Application: SSI 7485

I write regarding the proposed modification to M4-M5 Link, Mod 2 The Crescent overpass and changes to pedestrian infrastructure in North Annandale, Rozelle and Rozelle Bay Foreshore area.

Figure 4-2 Pedestrian and cyclist bridge infrastructure options

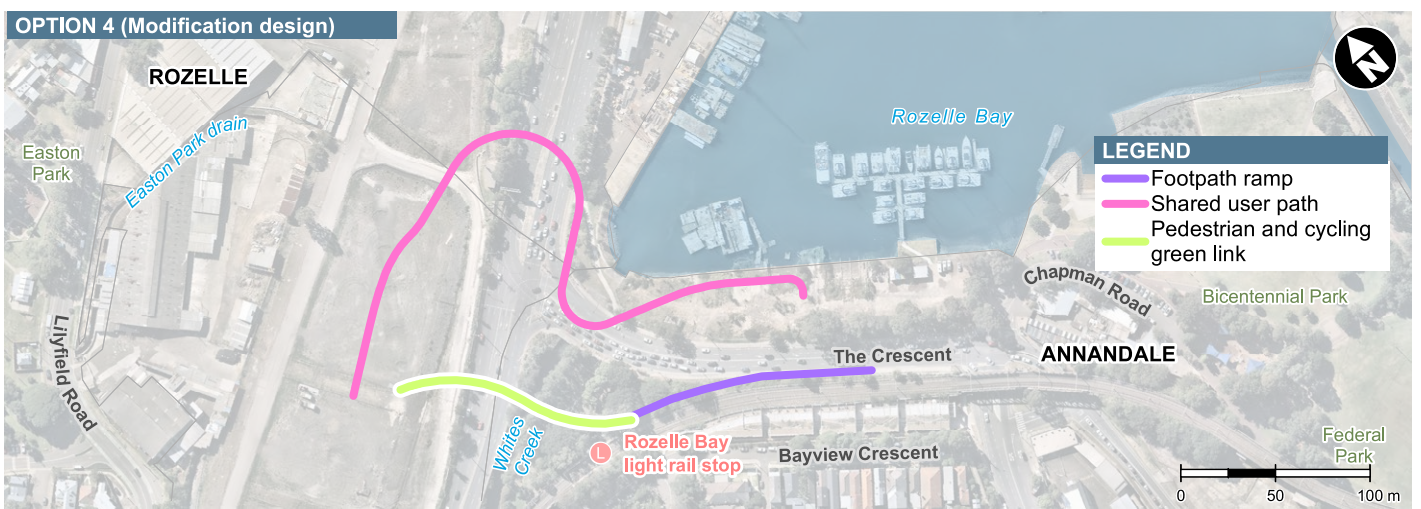
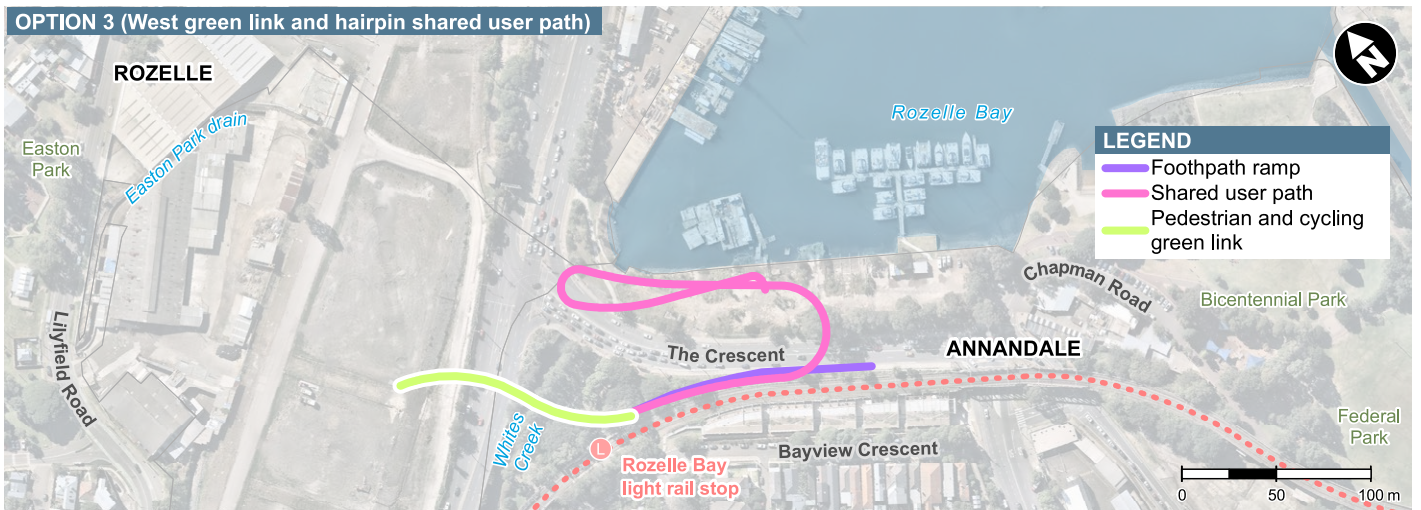
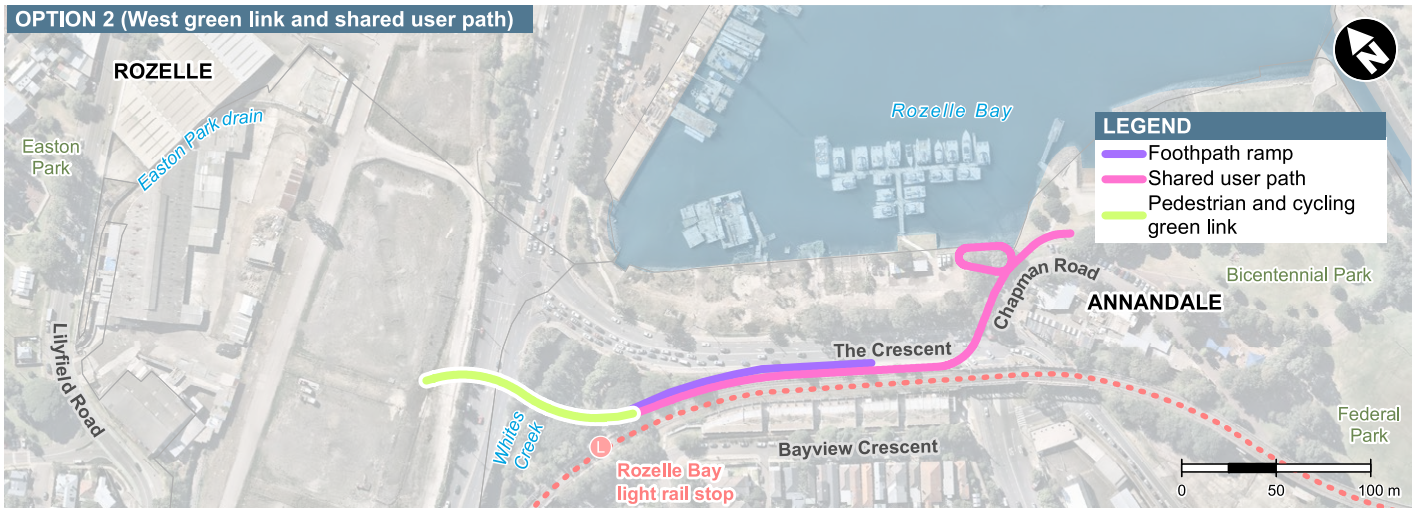
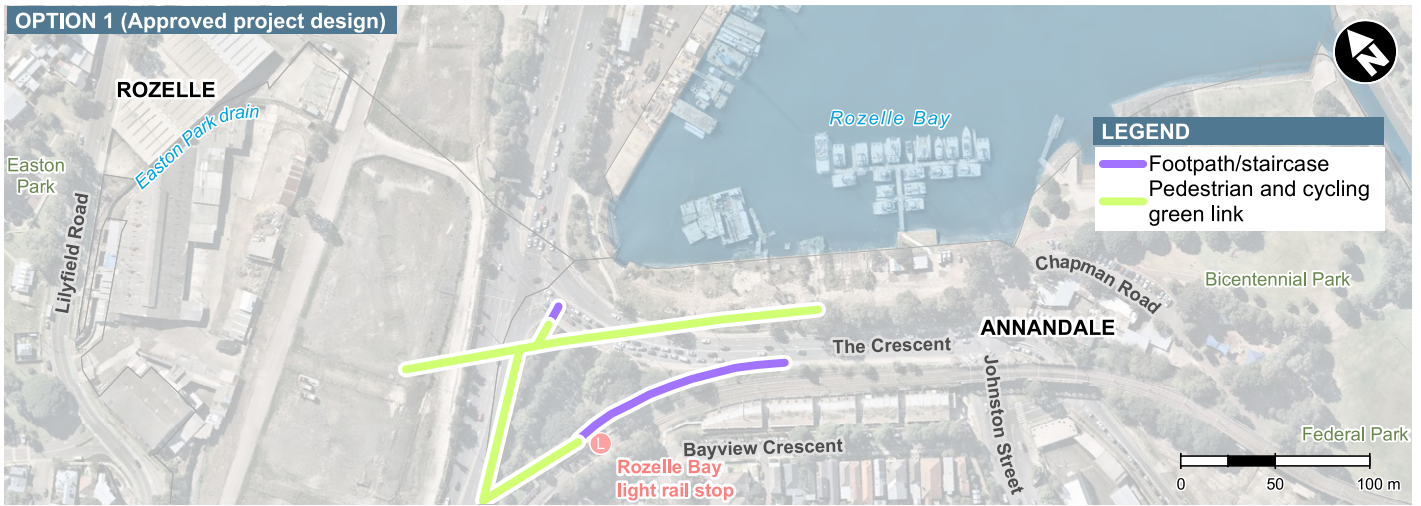
I request RMS work with the community to explore alternate design options to the proposed new car overpass design and the changed pedestrian and cyclist links. I am seeking the reinstatement of the safe, direct access from the approved EIS GreenLink to create a continuous green open space connection from the Rozelle Rail yards and Annandale to the foreshore. The GreenLink was more than just a walk way - it put people central to the design, maximising safety, and providing much needed accessible open space for the community now and into the future Bays Precinct design.

- Reinstate the GreenLink connecting communities and green open space from Rozelle to Bicentennial Park
- Relocate and design pedestrian and cyclist connections that are continuous, safe and direct.
- Design the modification infrastructure and active links in response to the character of the suburbs, the location of the foreshore and it's potential future development.
- Provide pedestrian and cyclist paths that maximise people safety and do not force them onto busier streets, unsafe concrete plazas and caged walkways.
- Integrate active and direct connections to all active transport – including the future Metro West and Foreshore Ferry Wharf

Figure 4-4 Elevation: Indicative view of The Crescent overpass

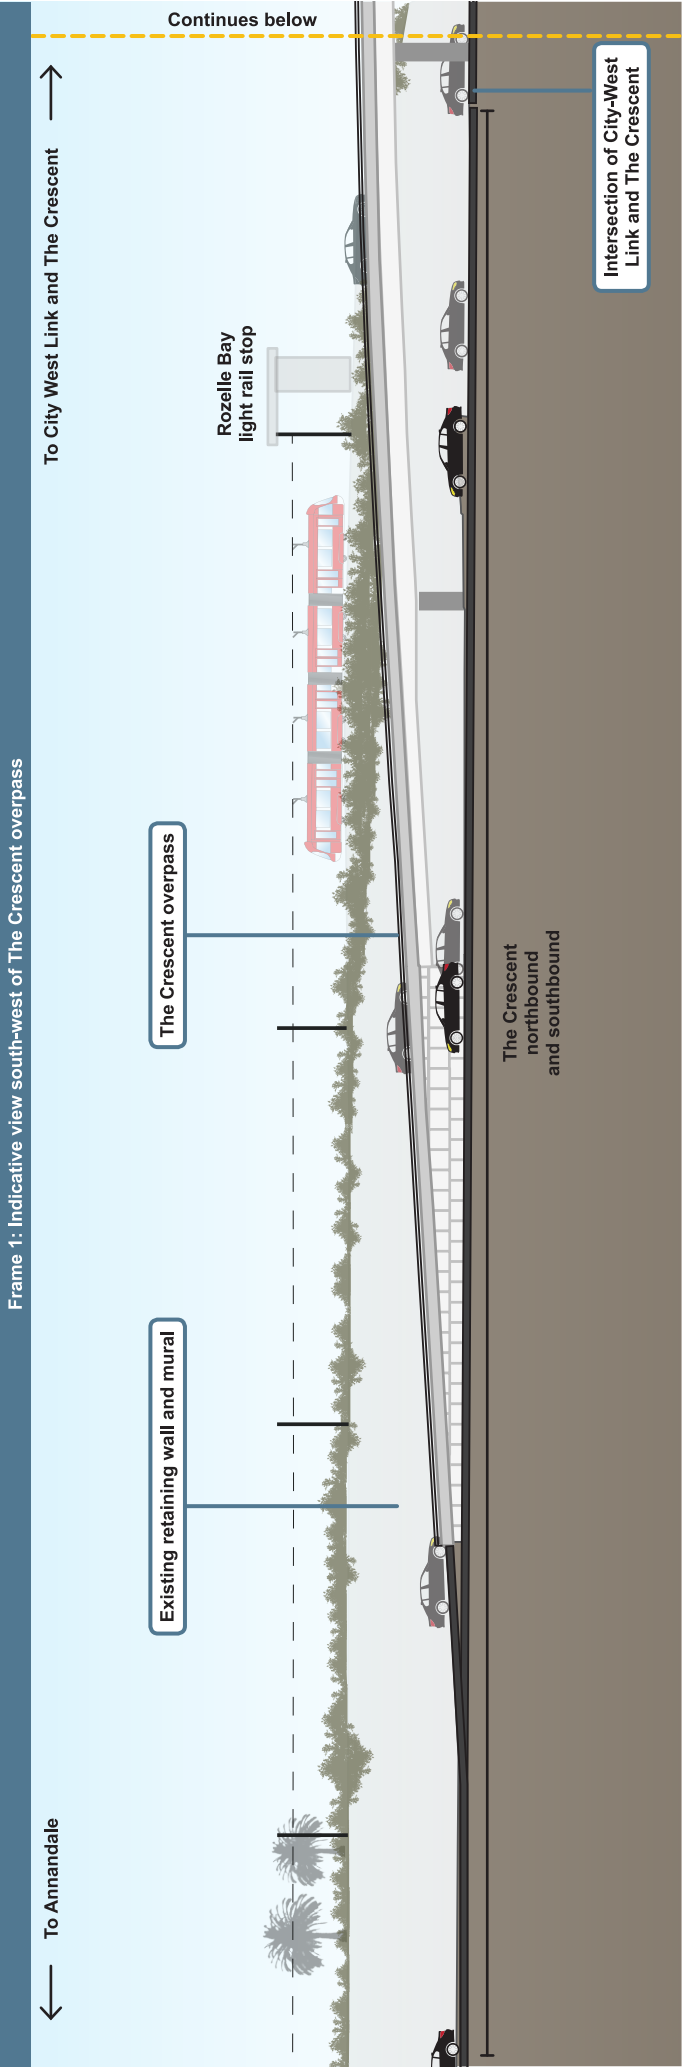
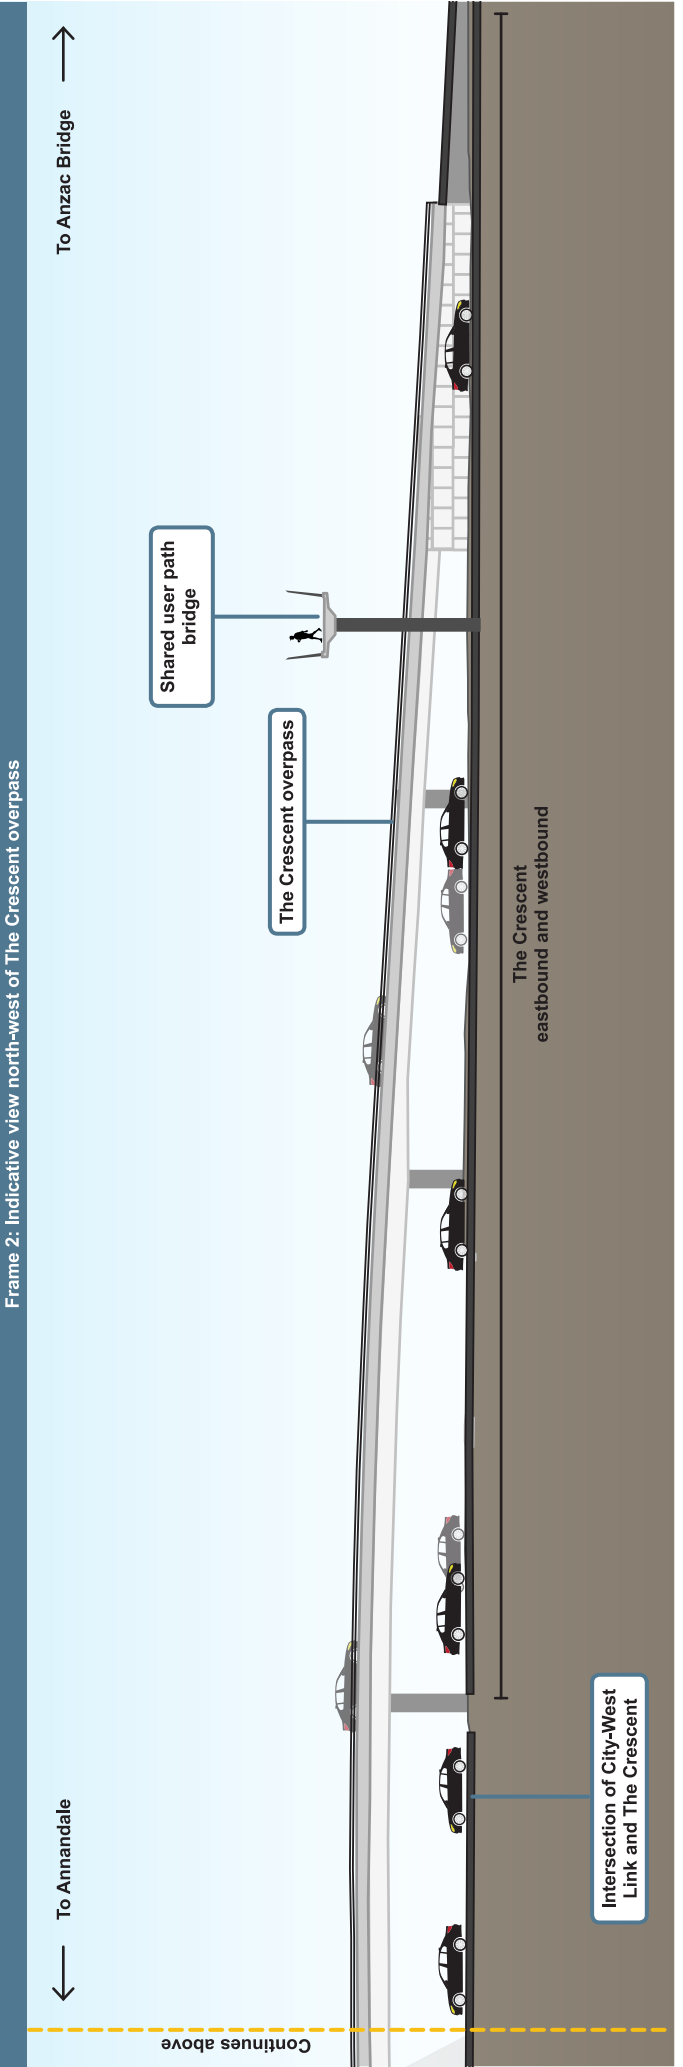
- The significantly reduced safety and increased risk for pedestrians and cyclists with removed access over The Crescent to Bicentennial Park and the increased traffic along Johnson Street.
- Being required to cross five sets of pedestrian lights at The Crescent as my option to reach the foreshore from Annandale or from Rozelle Bay light rail stop.
- Removal of direct active links to the foreshore, cutting the community off from the area and the proposed revitalisation of the entire Bays Precinct, including linking the Light Rail and Bus stops to a Ferry wharf and Metro station.
- Urban and landscape design that is being built before a finalised Masterplan for the area.
- Traffic changes that limit movements around the suburb and create further congestion in the local streets of Annandale, Forest Lodge, Glebe, Lilyfield and Rozelle with no planning to deal with these.
